HIGH PLAINS FILING NO. 1

PRELIMINARY PLAN

SECTION 19, TWP 11 S, R 65 W OF 6TH PRINCIPAL MERIDIAN EL PASO COUNTY, COLORADO

HIGH PLAINS FILING NO. 1		DESIGNED BY: DLM	DRAWN BY: DBM
PRELIMINARY PLAN		SCALE: 1"=100'	DATE: 11/26/18
		JOB NUMBER: 17-135	SHEET: 1 OF 1

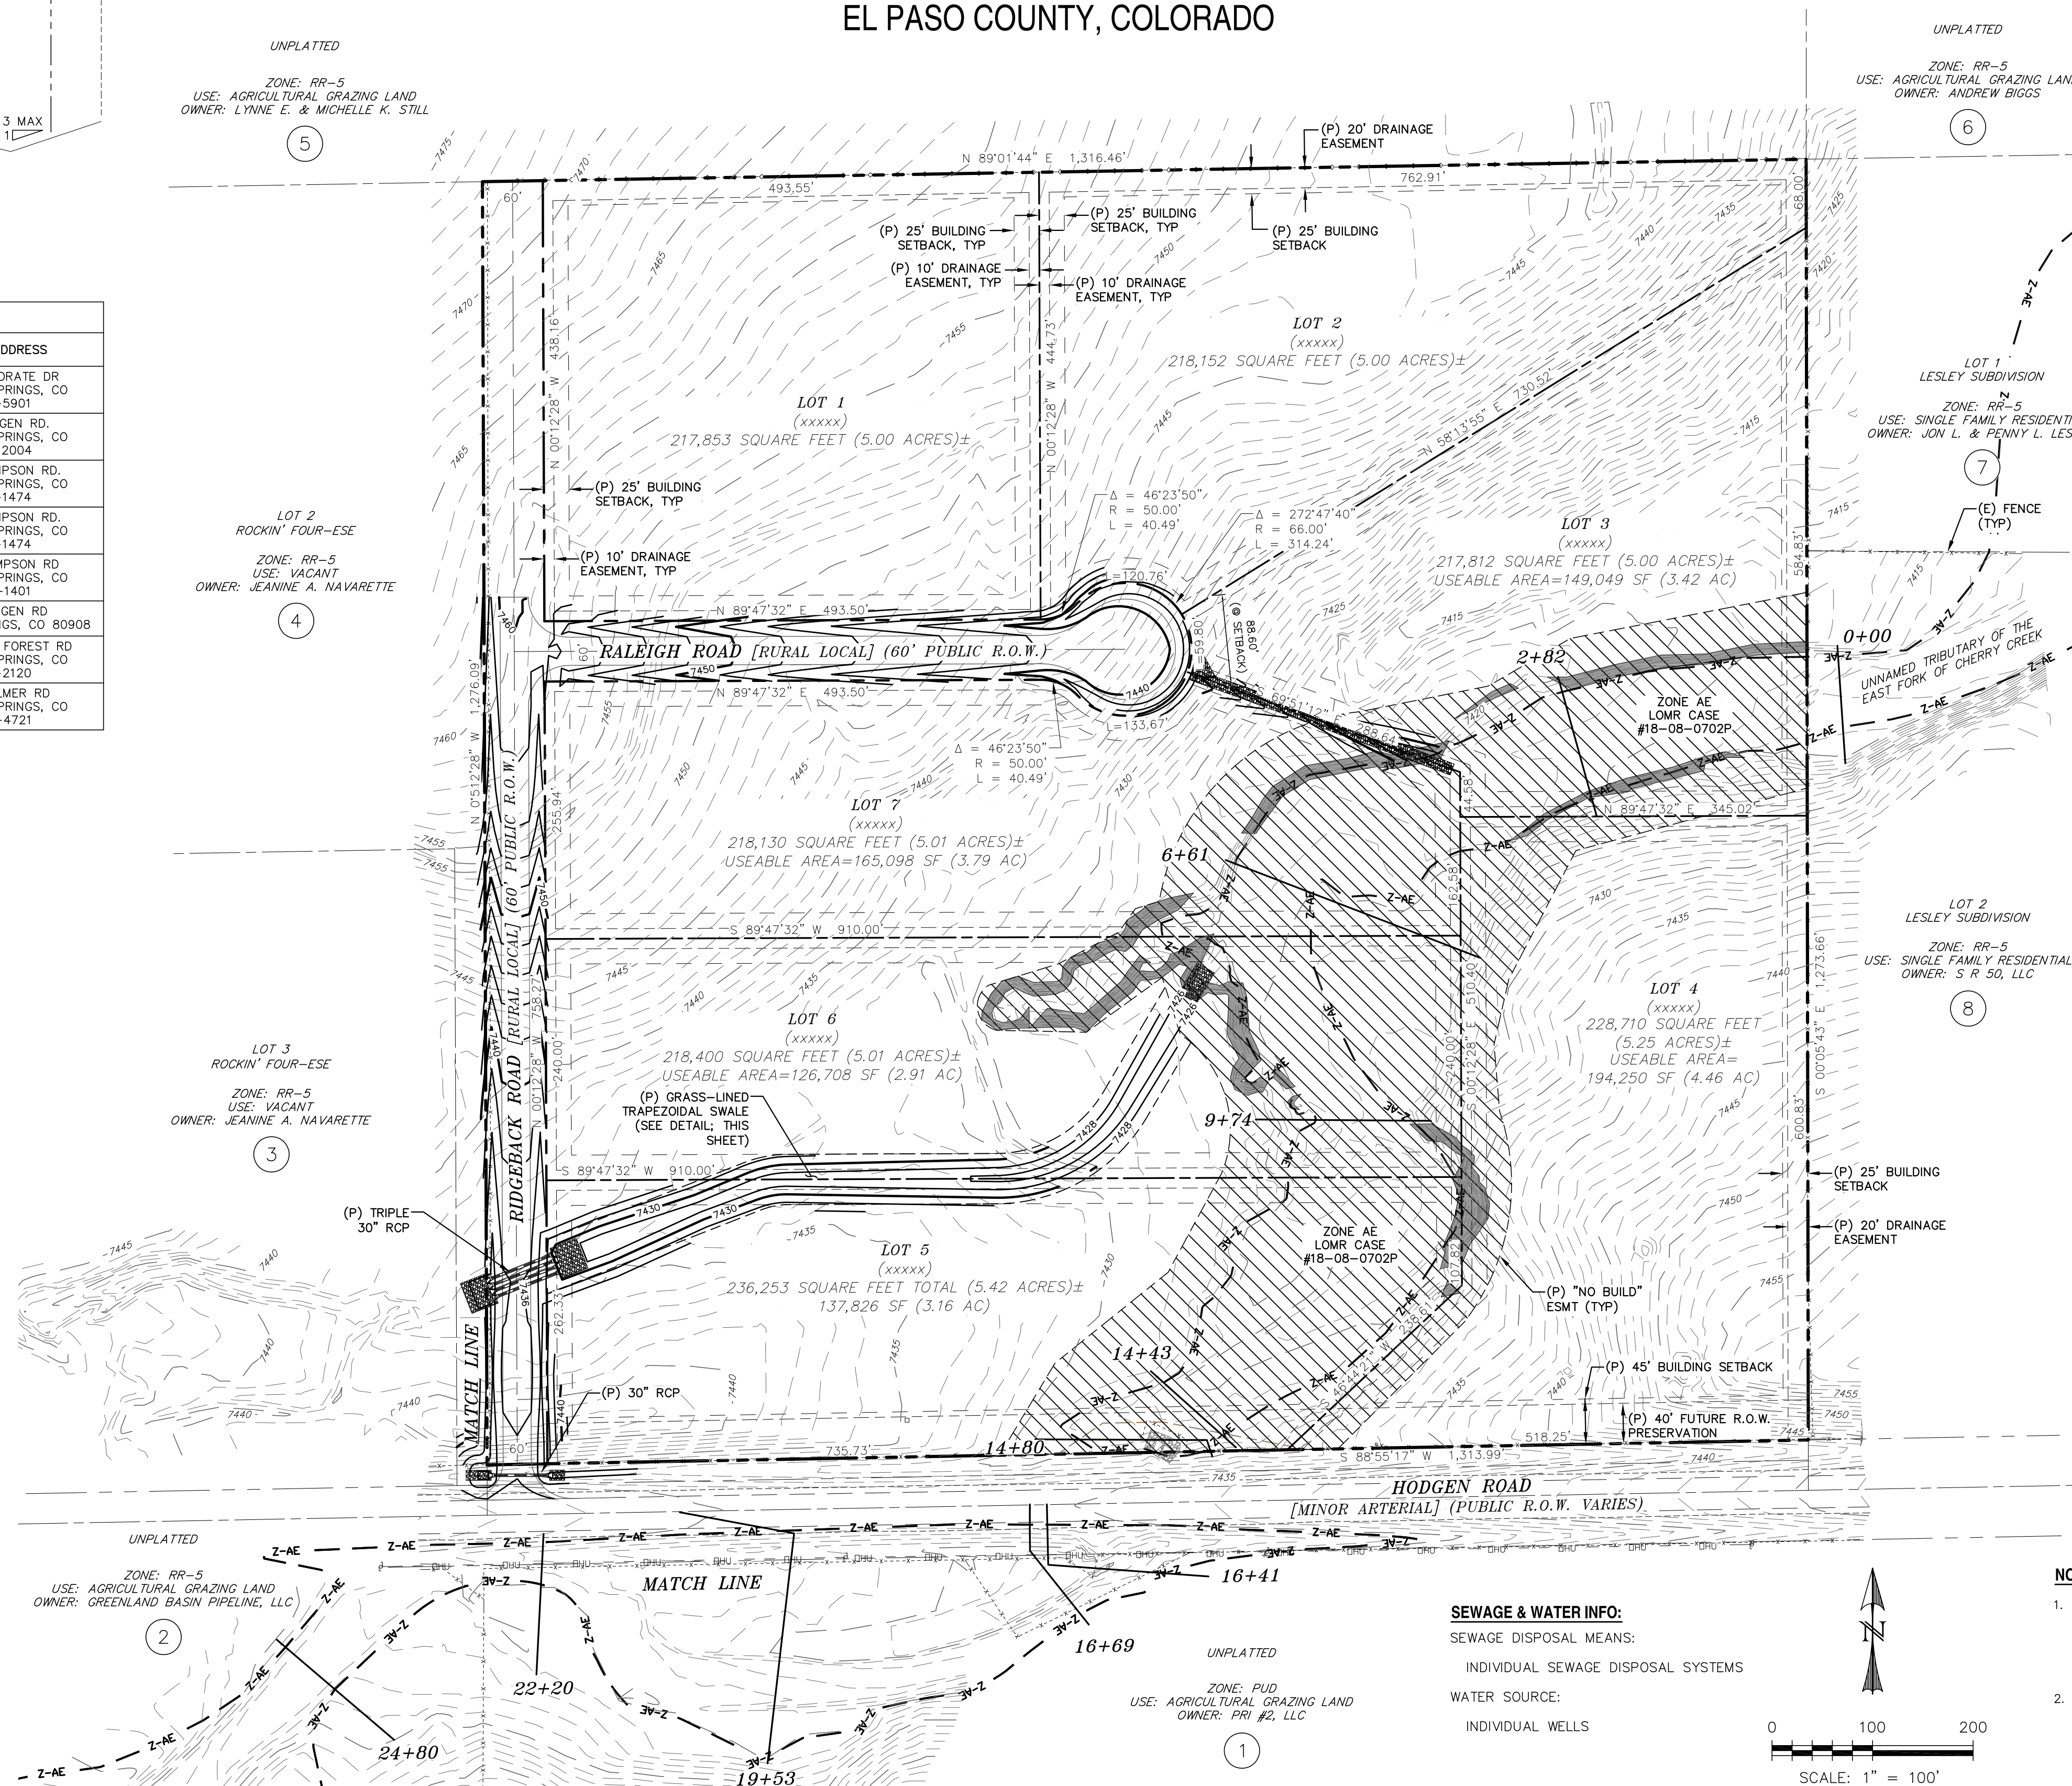
unresolved comment: there is no note pertaining to the soils and geology report and the potentially hazardous areas.
